Re Gunnedah Waste Facility

Application Number SSD-8530563

We write concerning the proposed Gunnedah Waste Facility, to be constructed on Lots 1 & 2 DP 1226992 16 Torrens Rd Gunnedah.

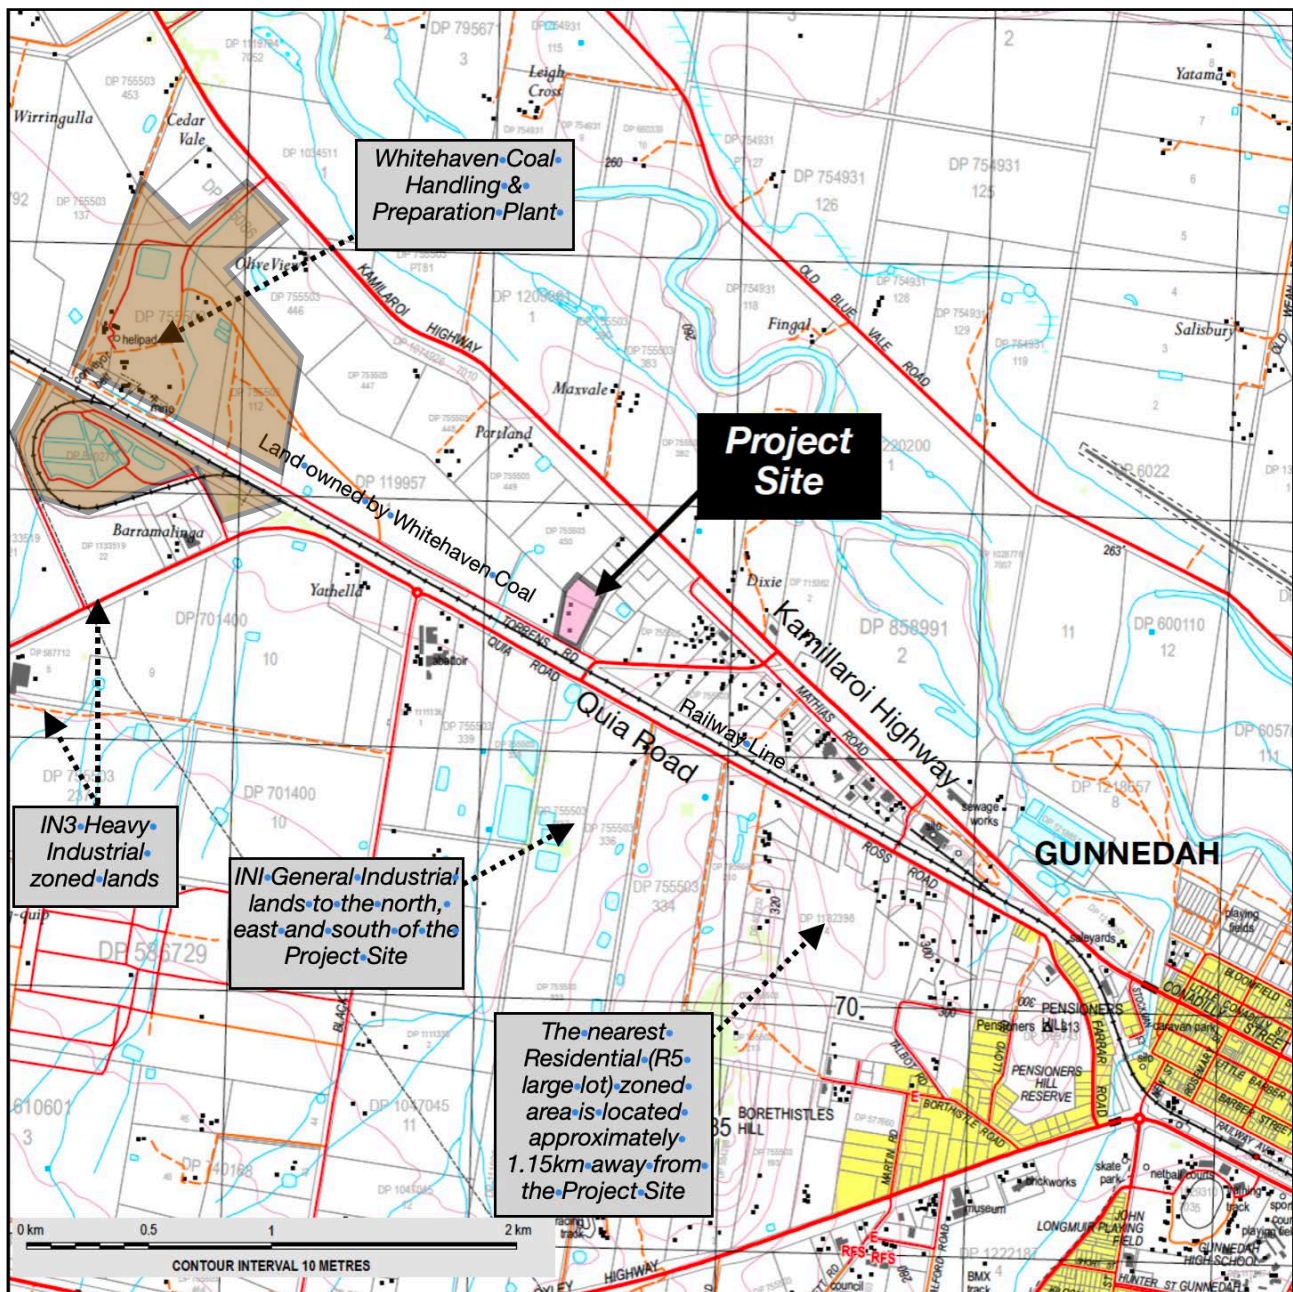
The EIS submitted for this project, implies that the nearest residential lots are 1.15 km away from the proposed development. Ref Figure 1

PRE-DEVELOPMENT OSD CATCHMENT PLAN

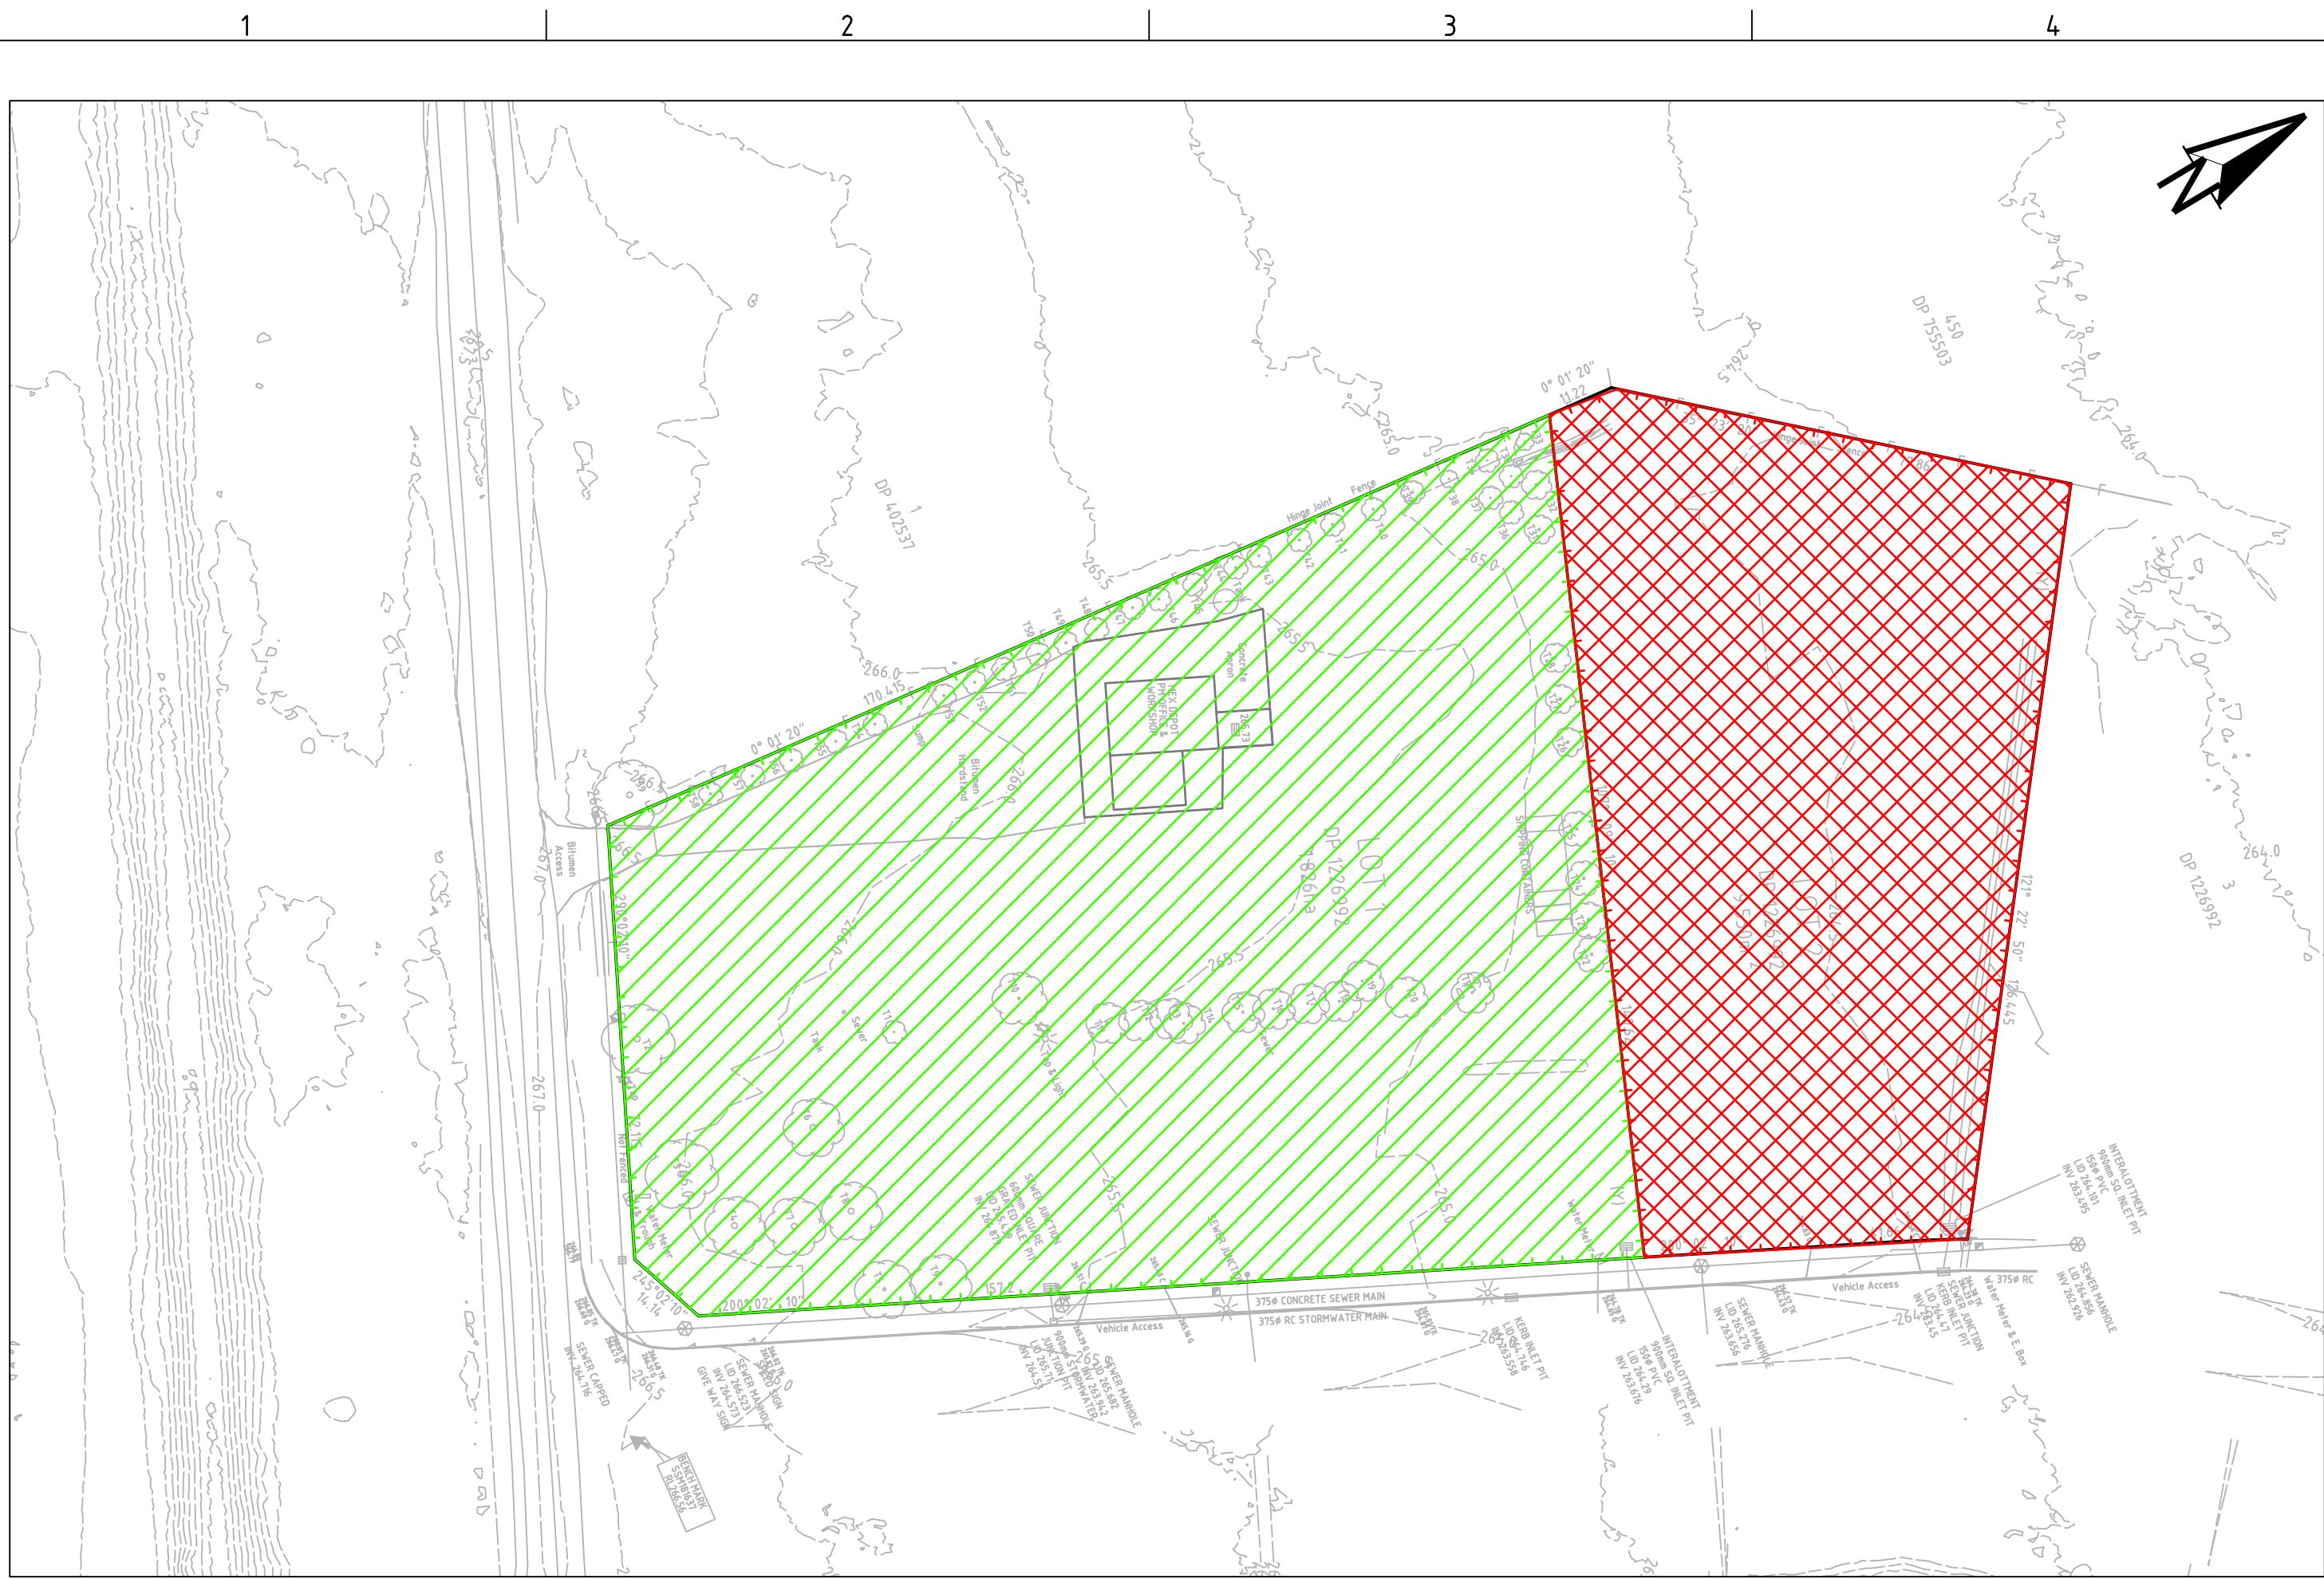
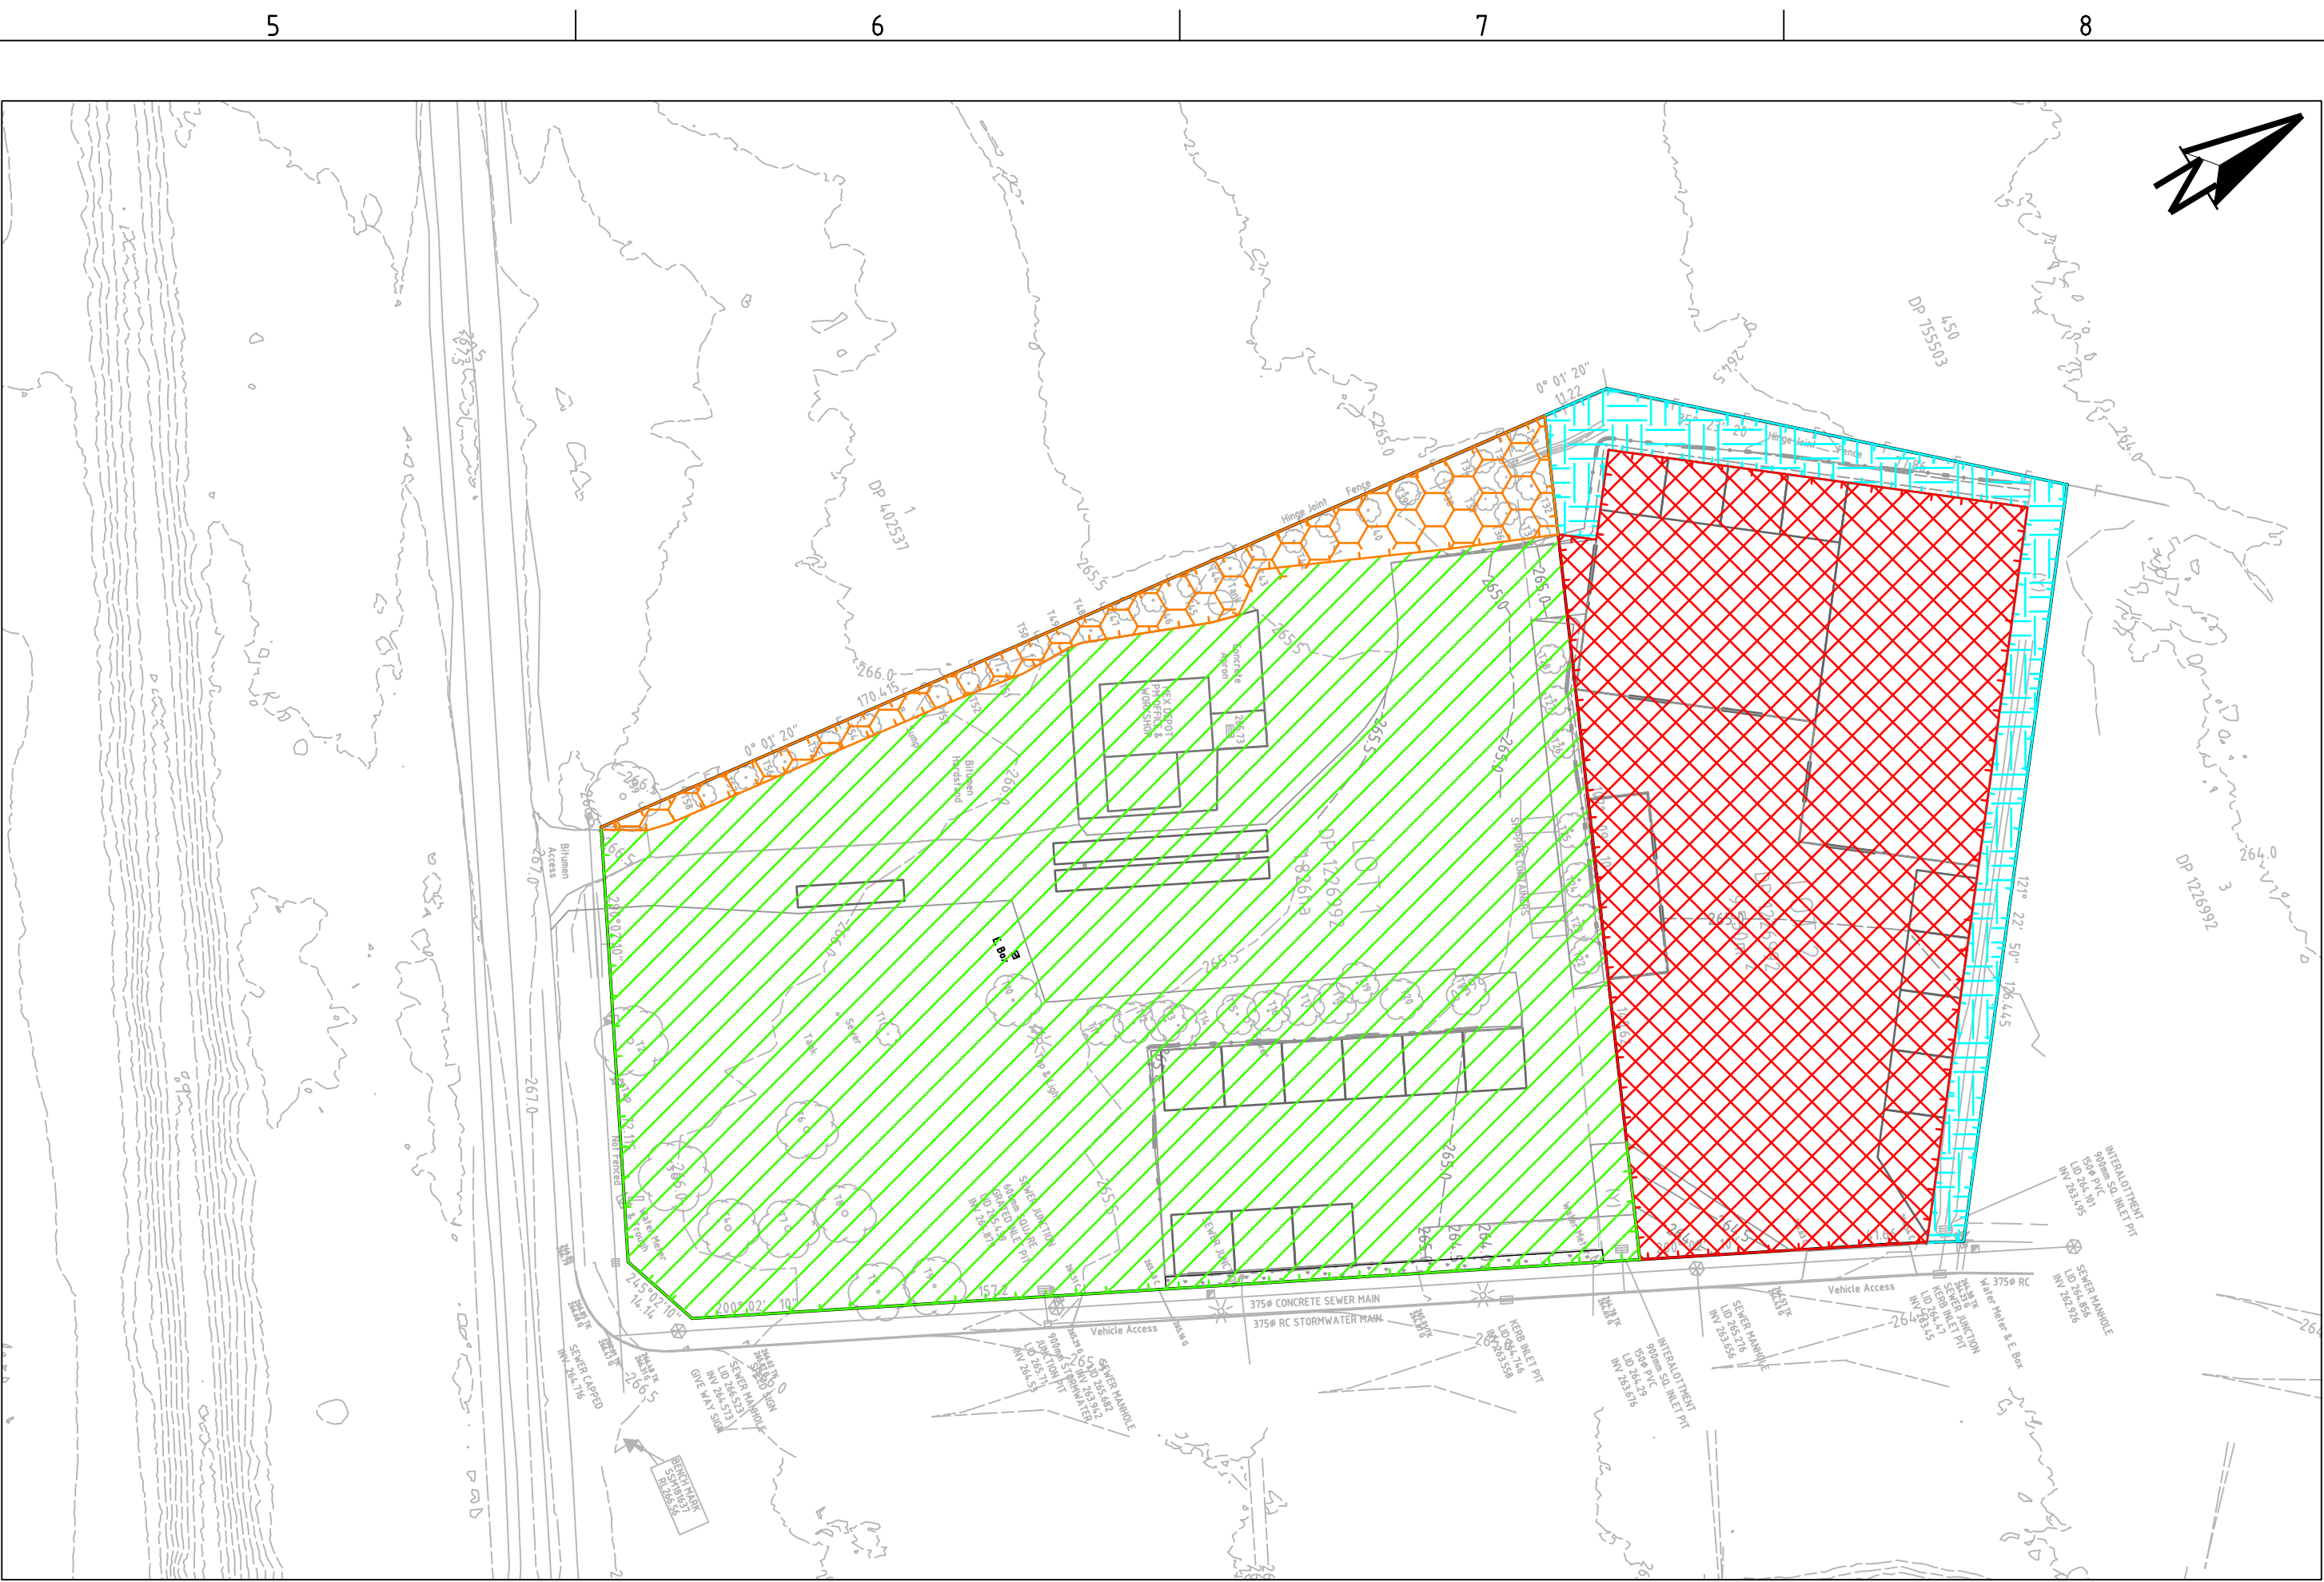
In fact the whole industrial sub division, of which the proposed development forms part, is subject to inundation.

In addition, there is extensive run off from Lots 1 & 2 DP 1226992 during heavy rain events which impacts properties to the west of that site

In addition, during heavy rainfall, runoff from the proposed site of the waste centre, impacts neighbouring properties.
